Re- Planning Application - 2021/62/91239/W 410/412 Birkby Road

14 September 2021

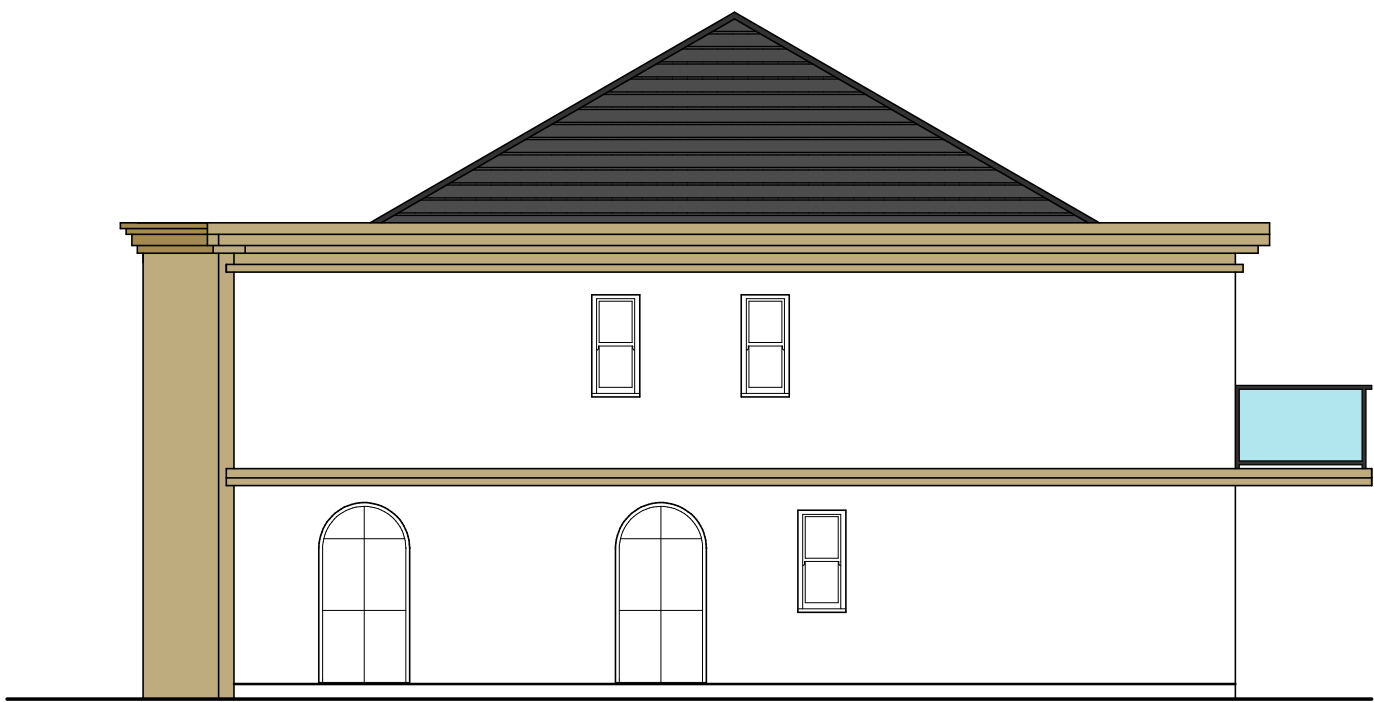
The current plans still do not address any of the objections relating to our privacy, in particular the windows and balconies that will look directly into our property from 410 Birkby Road, see attached side elevation. The existing house (410) had to be a bungalow to avoid any privacy and environmental issues with no clear windows on the east side. Why does it appear that this requirement is now simply being overlooked?
